From: Contact Centre (CRM) <contact@ribblevalley.gov.uk>
Sent: 09 March 2023 11:11
To: Planning
Subject: Planning Application Comments - 3/2021/0660 FS-Case-495124745

Planning Application Reference No.: 3/2021/0660

Address of Development: Newton in Bowland

UNITED UTILITIES WATER LIMITED
HAWESWATER AQUEDUCT RESILIENCE PROGRAMME
PLANNING APPLICATION BOUNDARY
PROPOSED BOWLAND SECTION
PAGE 6 OF 6

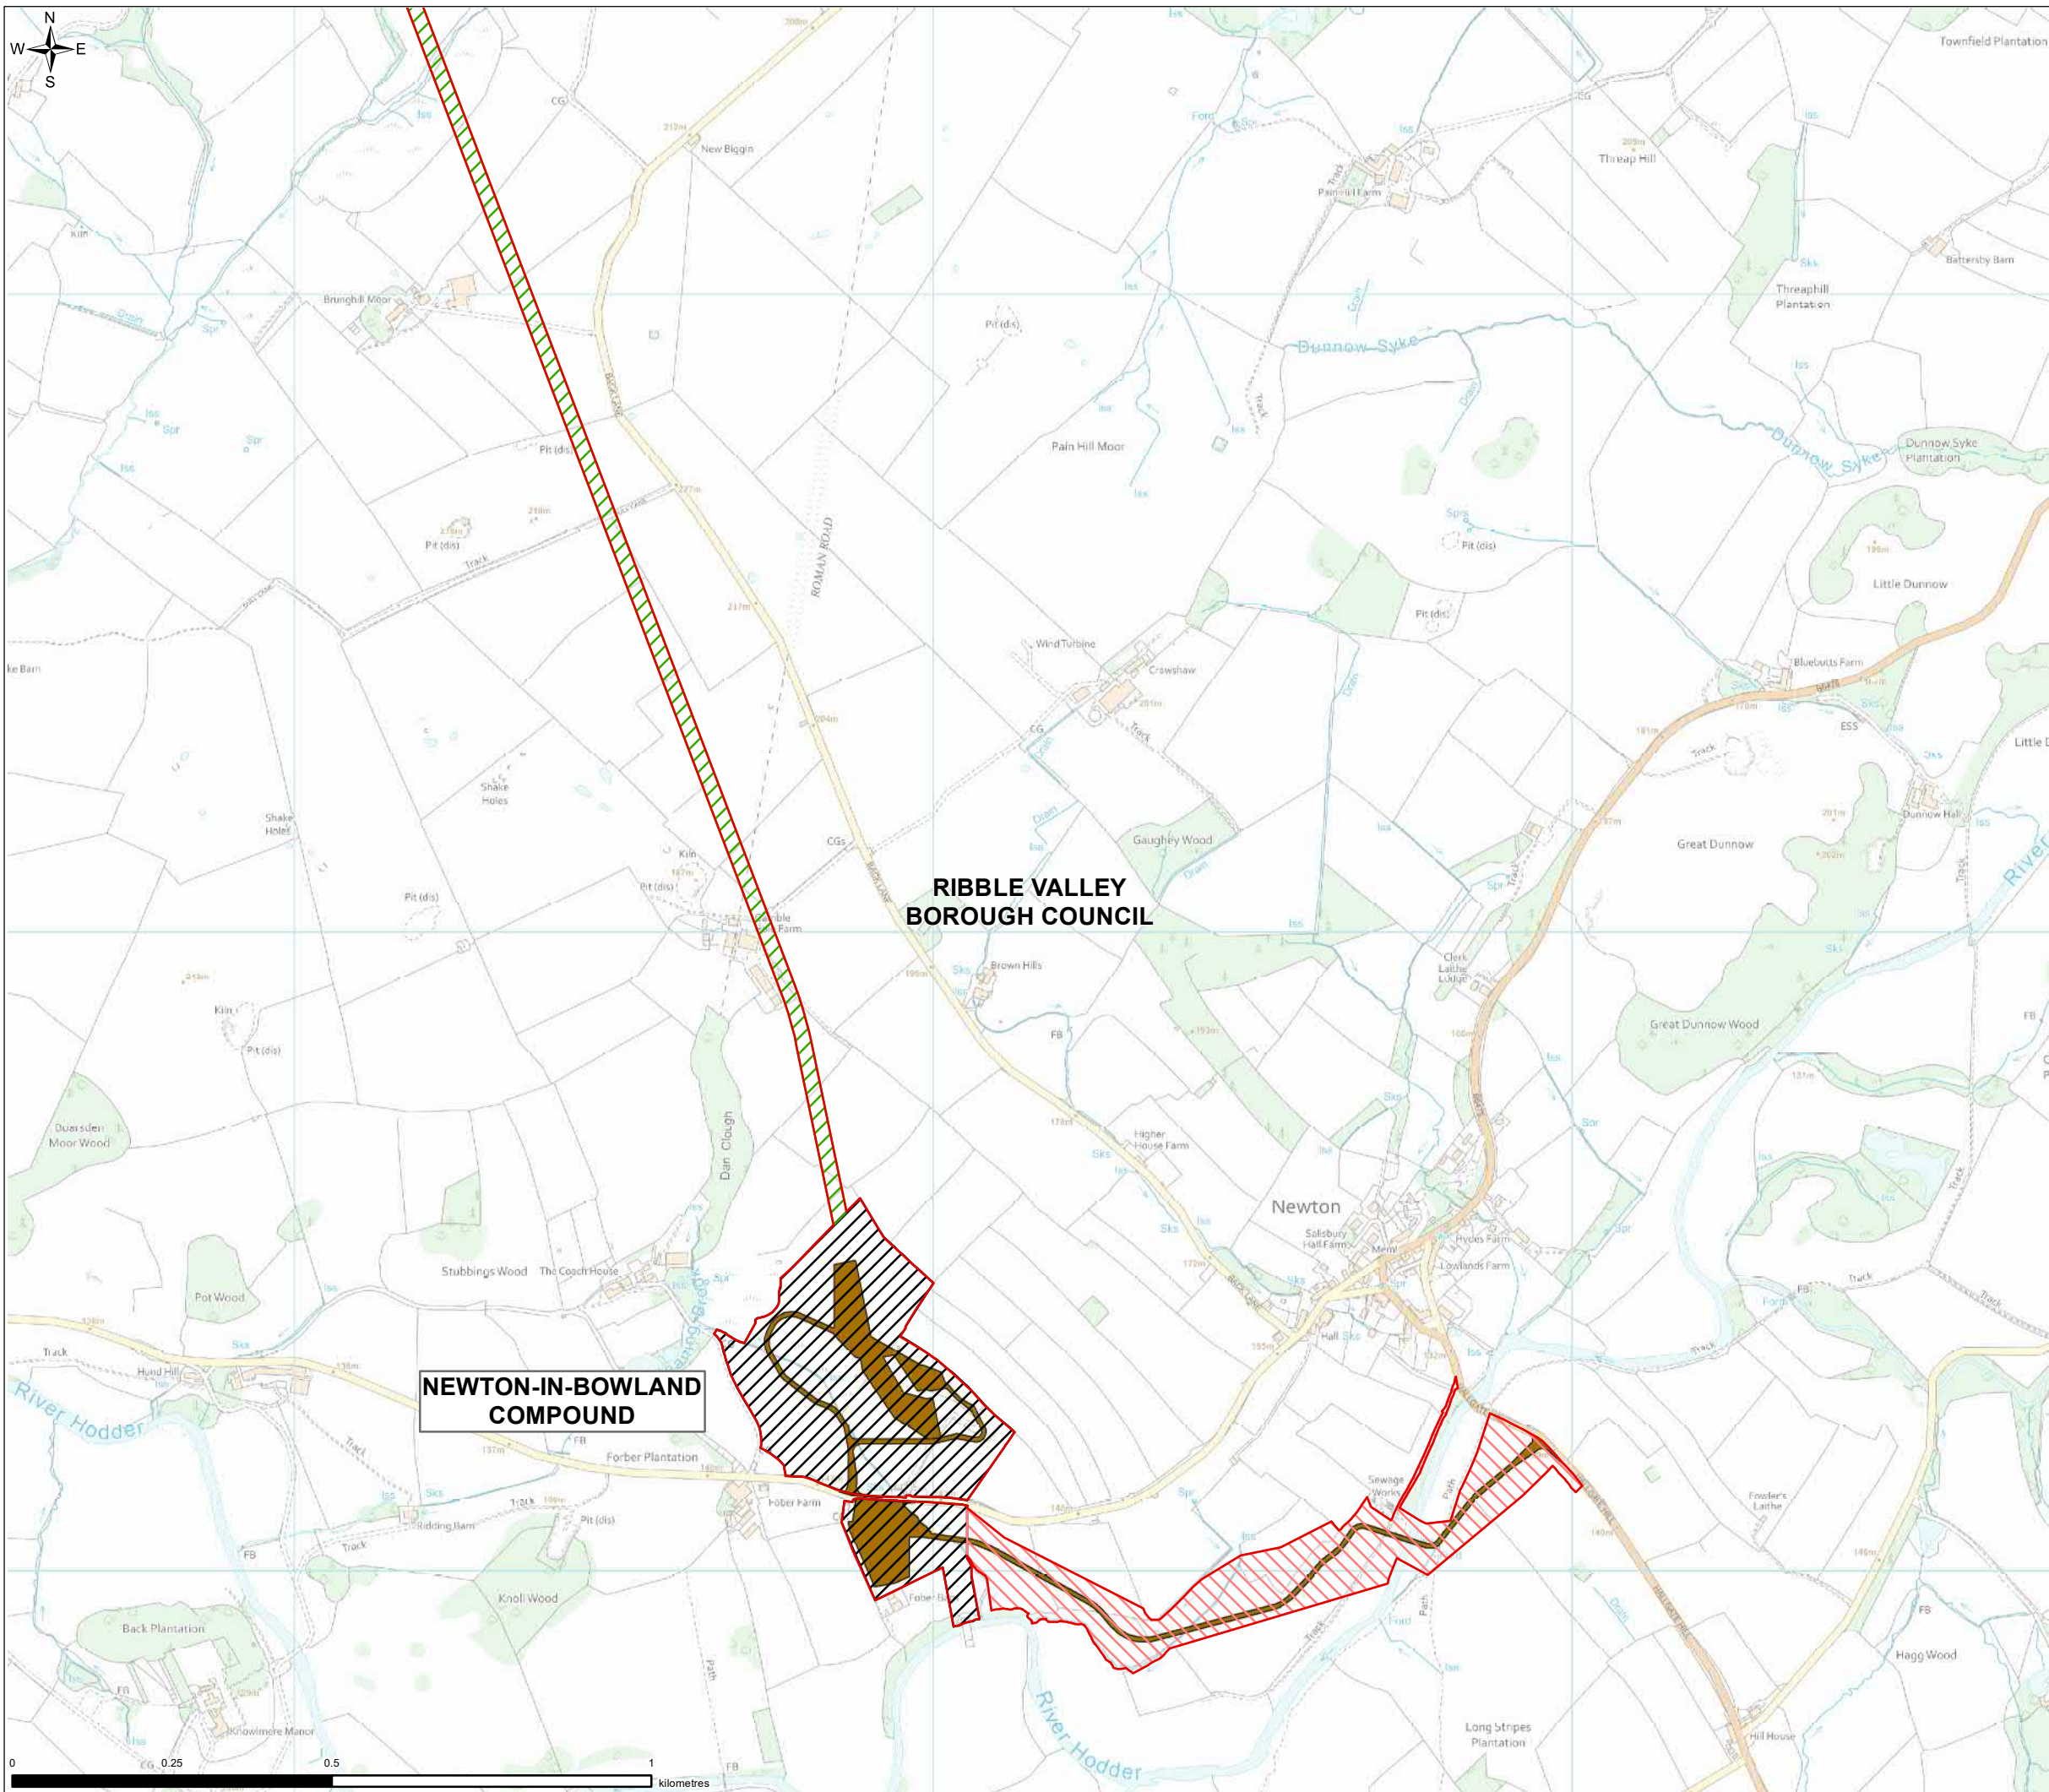
- The proposed 'boundary' lines for the Newton compound now include a significant amount of car parking spaces - not included and updated since the LCC application to use Waddington Fell Quarry

- The same compound lines contradict each other with one showing parallel lines to the tunnel around Gamble Hole Farm and the other showing the compound sweeping over the single track, quiet, back lane. Rather than an error I suspect this may form part of a wider plan to access storage and vehicle and storage via back lane, despite previous assurances that no vehicles would do so.
